Our ref: Dendrobium Mine Extension Project (SSI-33143123)

22 July 2022

**Subject: Request for Additional Information – Water, disturbance area and employment related matters**

| DATE:<br>24 Mar 2022 | SCALE:<br>as shown | DRAWING No:<br>MSEC1181-08 | Rev No<br>A |

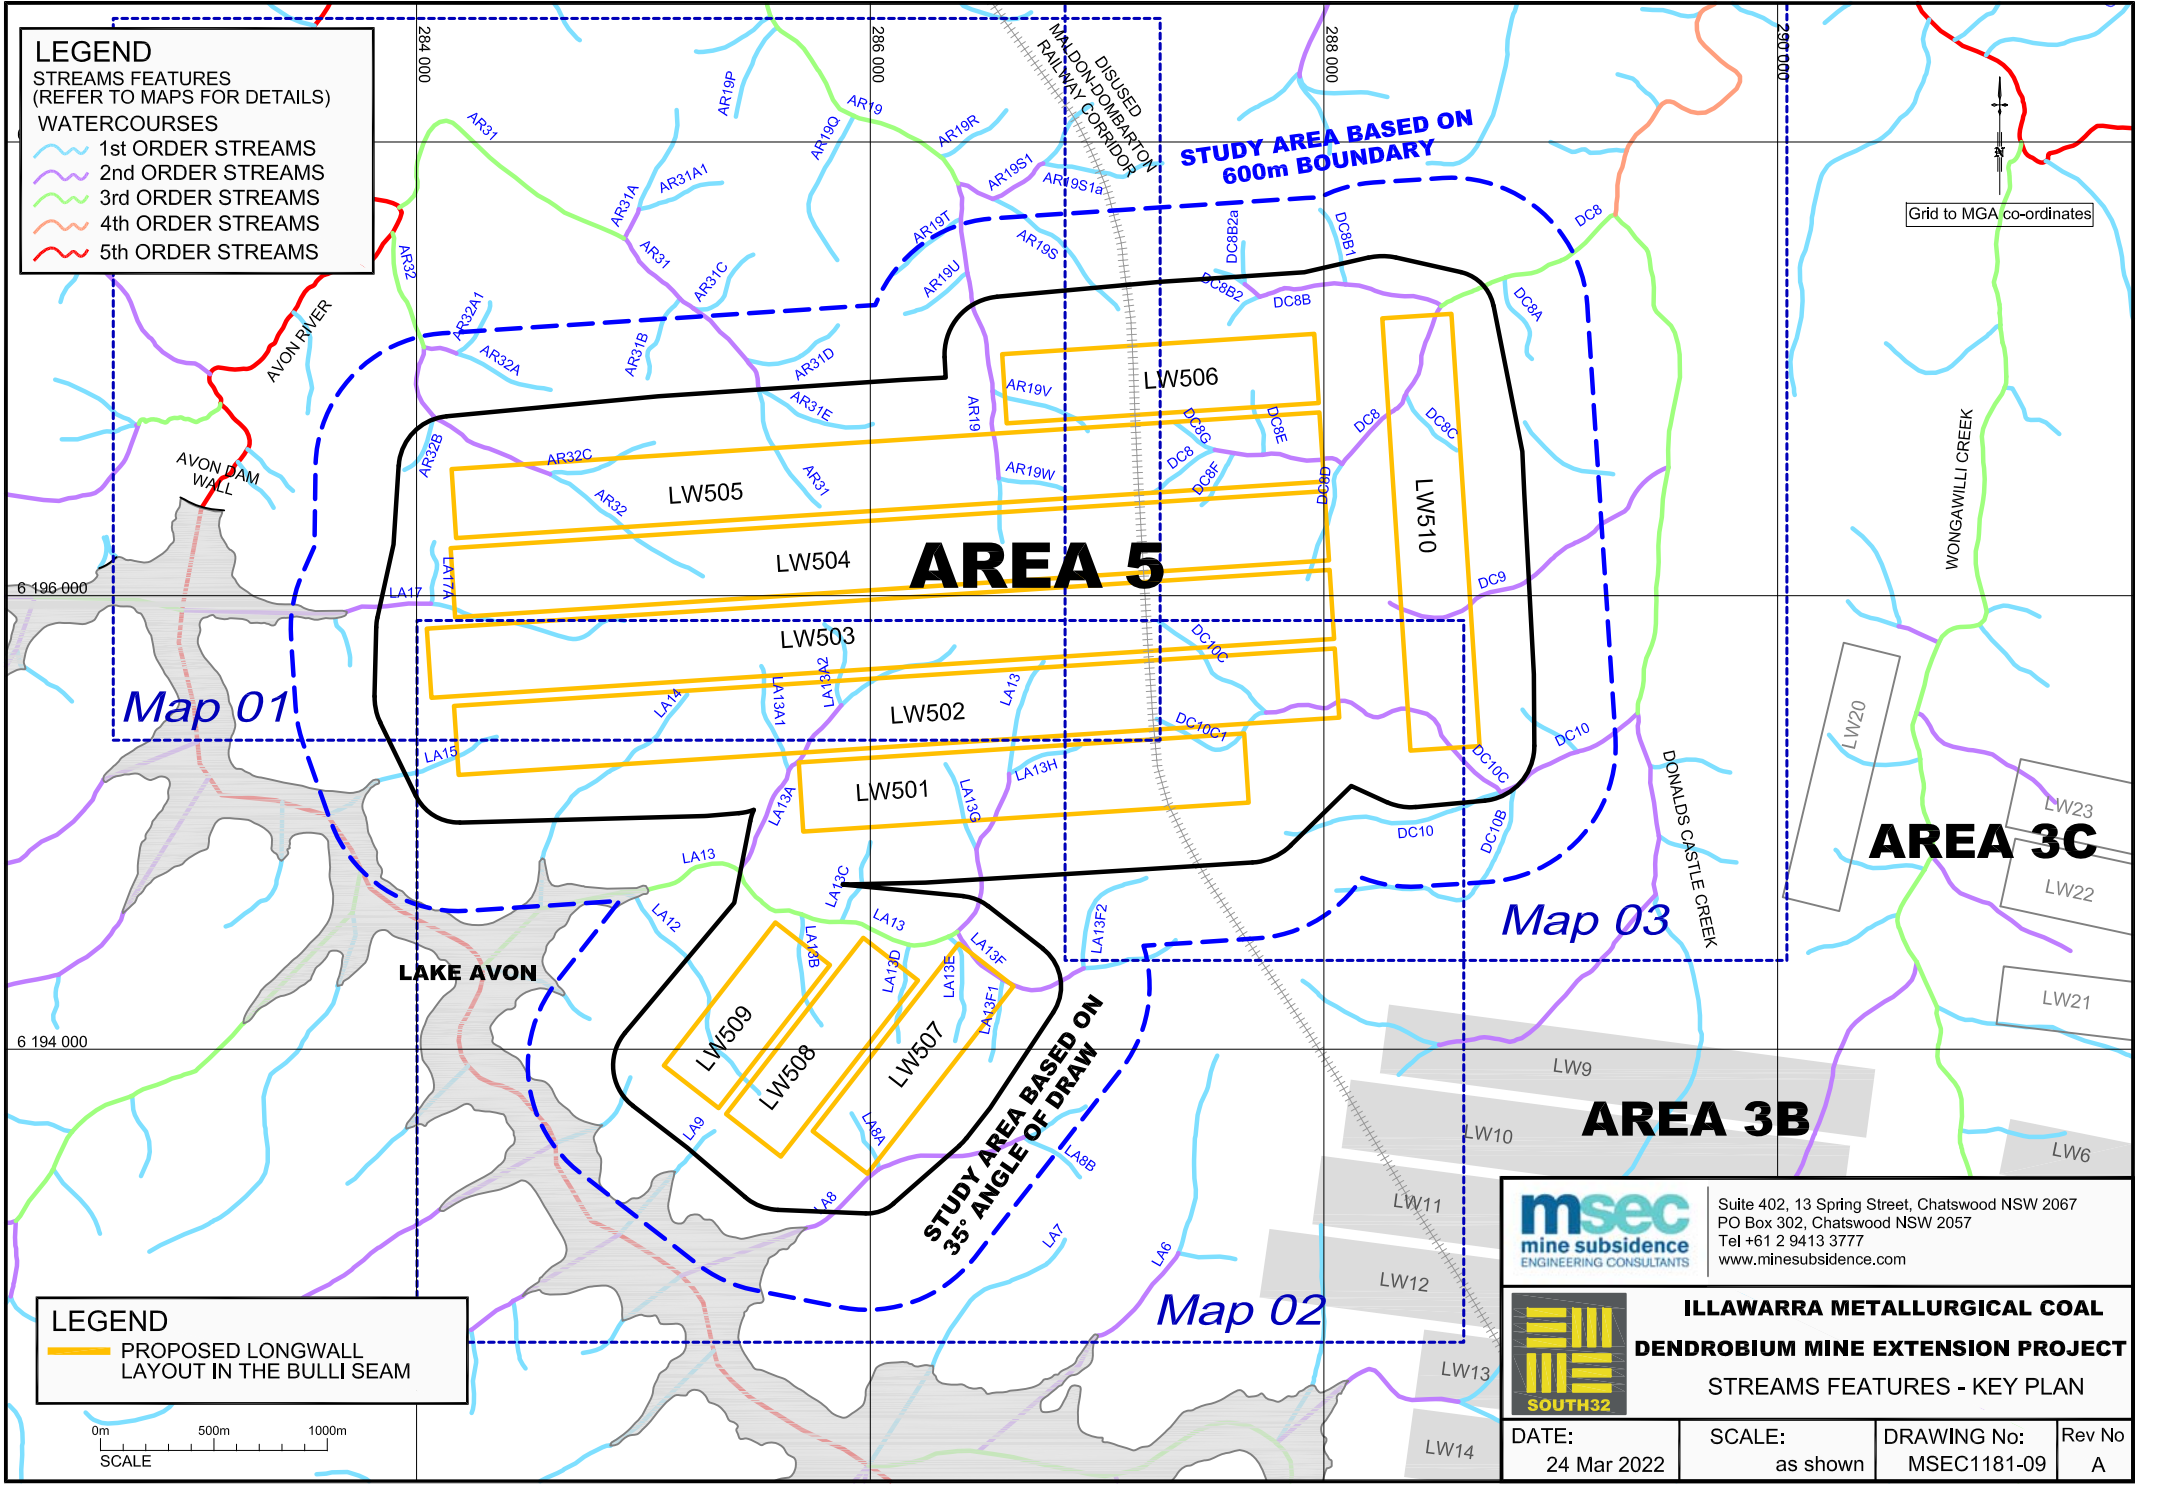
- One figure showing the location of key built and natural features in the vicinity of Area 5 (ie. consolidation of Drawings MSEC1181-08, 09, 14 and 15 of the Subsidence Assessment); and
- A revision of Drawing MSEC1181-09 of the Subsidence Assessment, including removing the Map 01-03 outlines and showing the location of the key stream features.
